Application No: 2015/93824

Proposal: Outline application for erection of 56 dwellings and care home with associated car parking

Location: Former Midlothian Garage, New Mill Road, Holmfirth, HD9 7LN

**Recommendation: OASD - CONDITIONAL OUTLINE APPROVAL
SUBJECT TO DELEGATION TO OFFICERS**

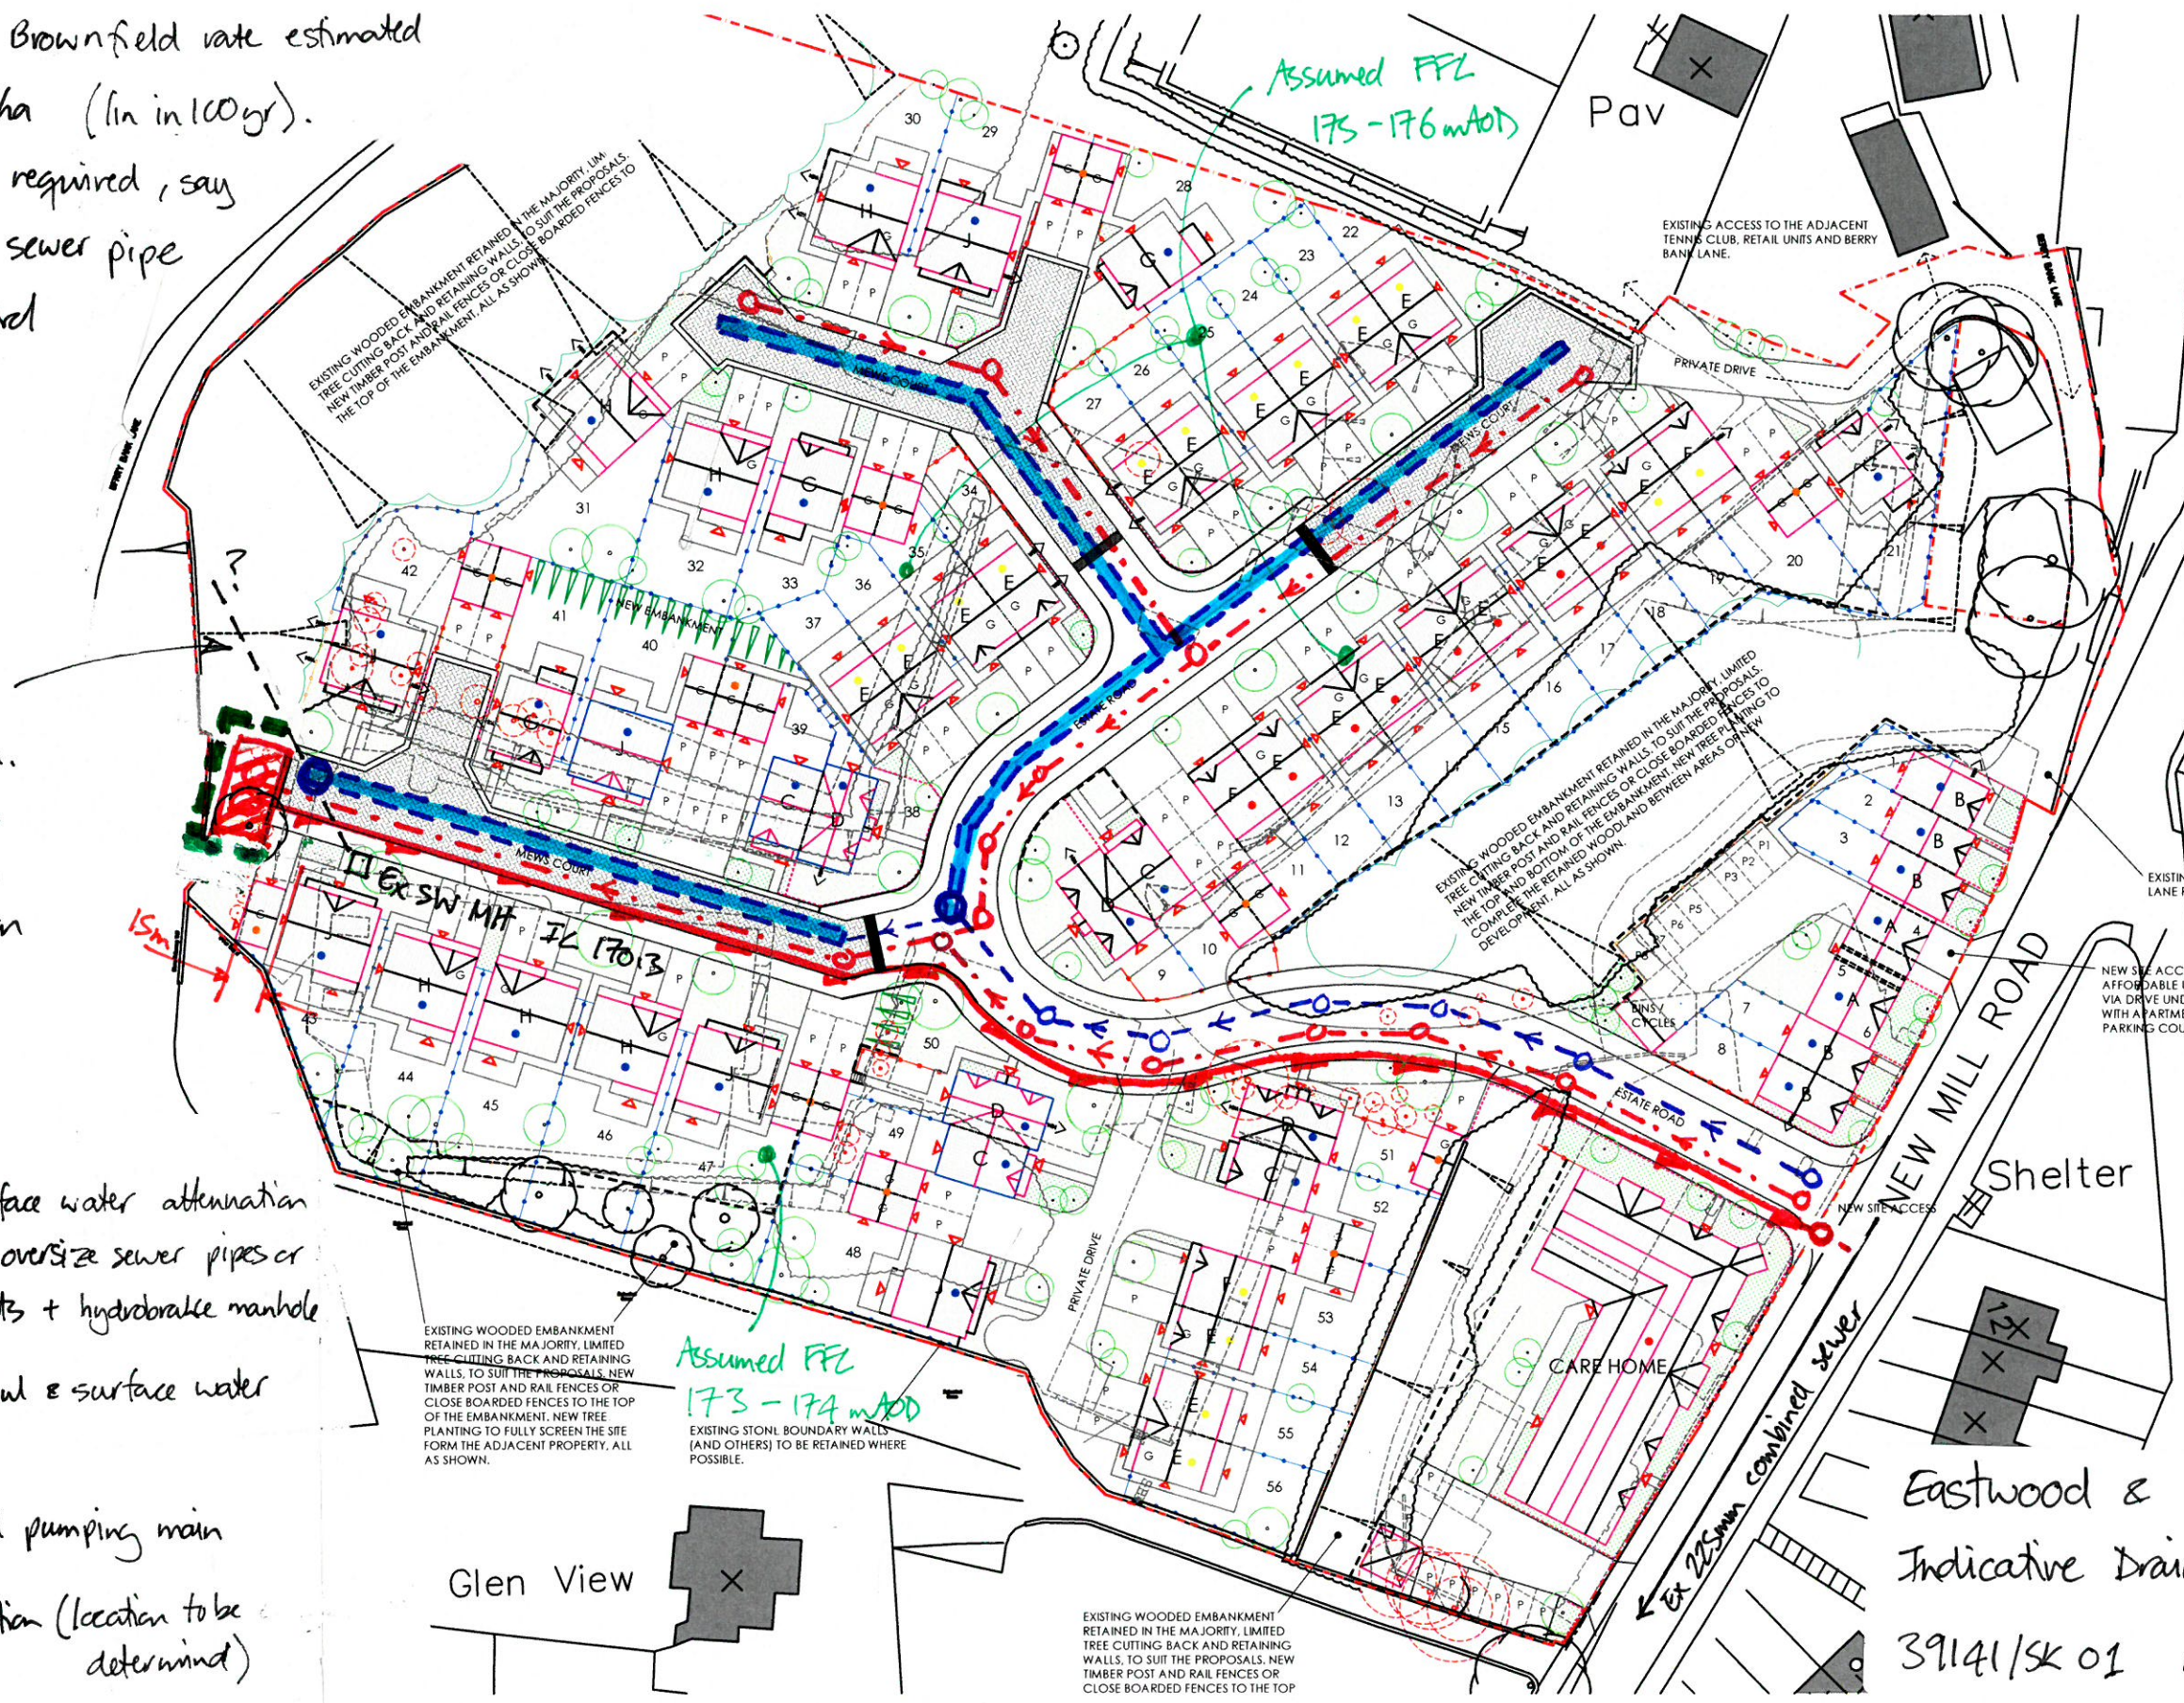
The drainage strategy does not fully consider the potential use of sustainable urban drainage systems (SUDS) for the development proposed. The indicative drainage layout proposes surface water attenuation storage within the site through the use of oversize sewer pipes or box culverts with the controlled discharge of surface water to watercourse via an existing surface water drain.

KC Flood Risk & Drainage advise that the potential for use of SUDS should be fully considered first before moving onto attenuation storage as an alternative method.

The figures for discharge rates should be based on greenfield run off rates as a maximum rather than brownfield given that the site has been cleared for some time and has therefore lost its place in the drainage system. Existing connections have not been surveyed and therefore discharge rates could be less with greater attenuation required which will need to be accommodated within the layout. A drainage survey will therefore be required to inform the drainage strategy.

Further information is required in respect of existing drainage and surface water flood risk. The risk is identified in the FRA as low, however the risk is present and needs to be accommodated. KC Flood Risk & Drainage advise that the FRA should be expanded to consider existing topographical surveys, surface water flood risk maps and surface water flows within the wider catchment in order to establish where surface water travels and ponds, and to inform the layout and drainage strategy.

TITLE SITE PLAN

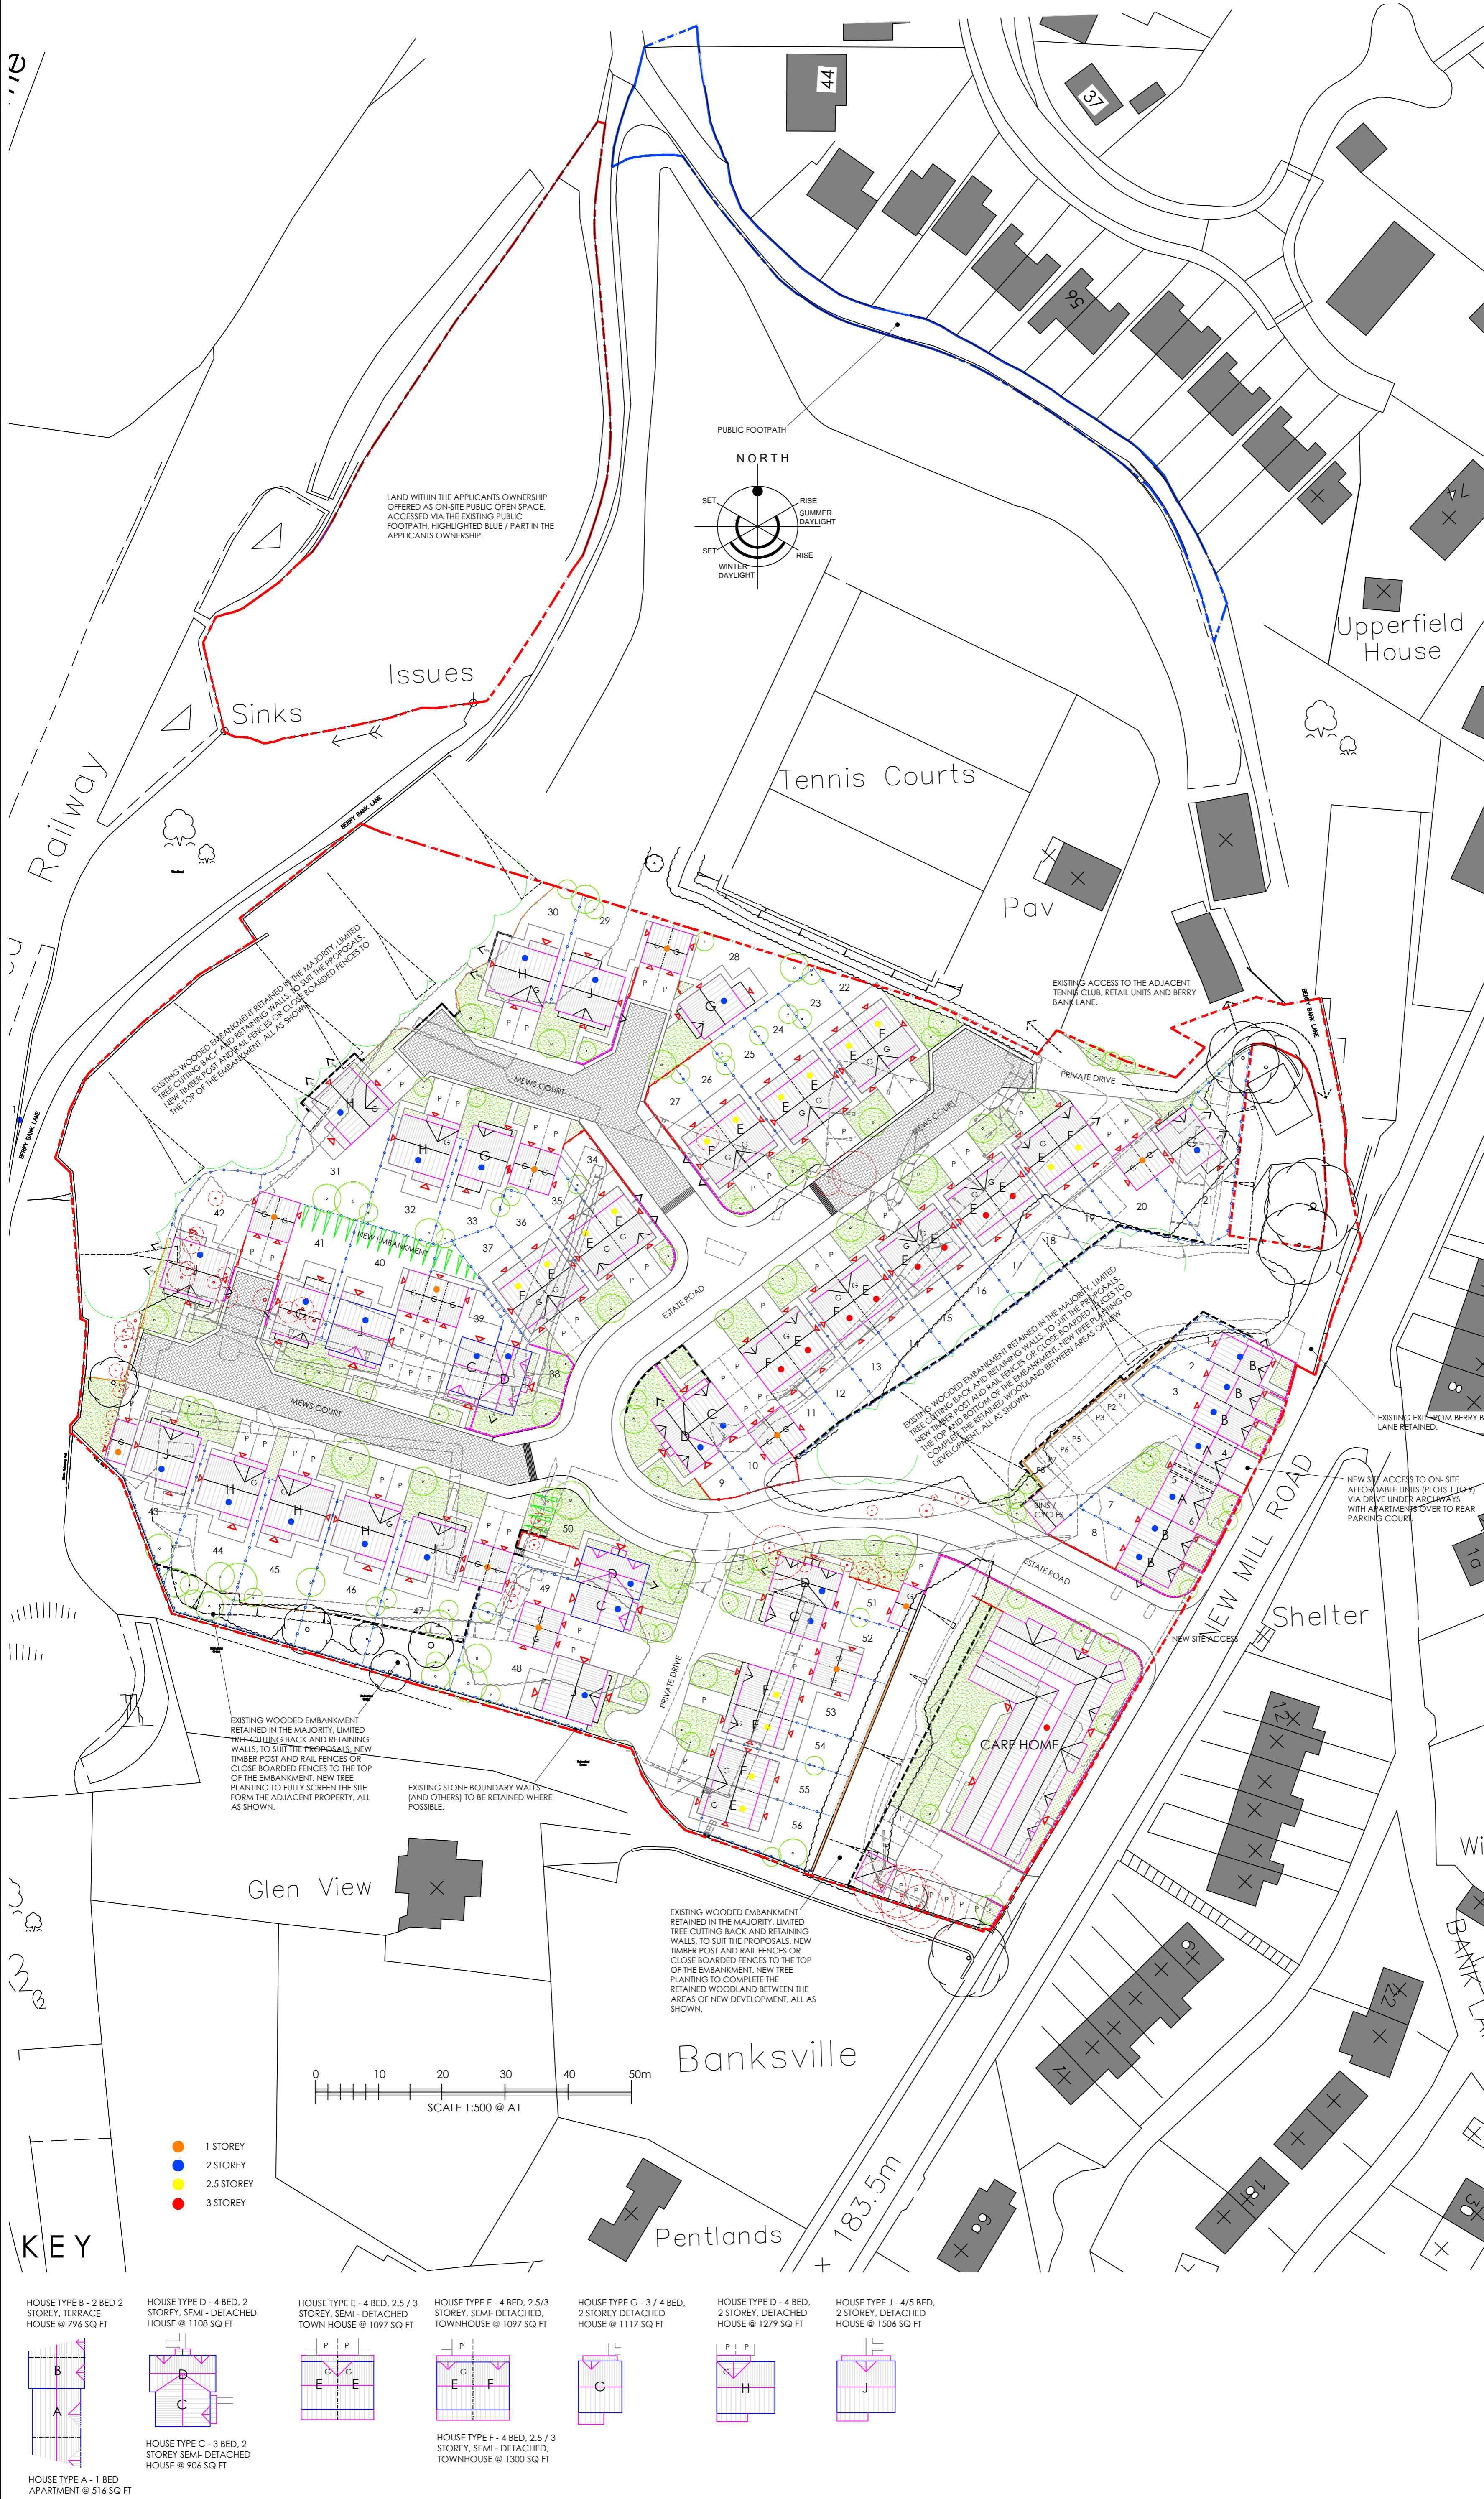
The indicative layout does not provide for public open space (POS) within the site itself. An area of informal POS is identified to the north of the site, accessible via existing public footpaths (HOL/50/30 & 80). Accepting that layout is indicative, the area of POS would not appear to be accessible from within the site and would remain essentially as is. KC Parks & Landscape consider that the POS provides negligible enhancement to the development proposed and therefore recommend that a contribution to improve existing POS off-site be sought in lieu of provision on site.

The layout indicates a visibility splay at the development access points to be 2.4metres x 58 metres for the care home access and 2.4 metres x 50.7 metres for the residential access road, these are in line with Manual for Streets standards. The visibility at the proposed access points into the development is below not what we would expect for a classified road. However as the applicant has submitted a speed survey which shows recorded speeds of traffic around the proposed junctions to support the MfS standard we would accept the proposed visibility splay on this occasion. In addition access into the existing car park and Bank Berry Lane has operated for a number of years apparently without any reported problems.

A terrace of dwellings is proposed to the north of the site access and a care home to the south. Whilst indicative, both are shown to be sited close to the back edge of pavement, creating a built frontage which is in character with and appropriate to the area. It is not considered that the use of the site as residential will have any adverse impact on residential amenities for neighbours, and that within the site there is sufficient opportunity to attenuate for potential noise from the tennis club, and adjust the layout to prevent any encroachment into the woodland areas, particularly that to the west.

With respect to privacy, the existing dwellings facing onto New Mill Road are in an elevated position to the site. The indicative layout shows minimum distances of 24-28m between the care home and the existing dwellings.
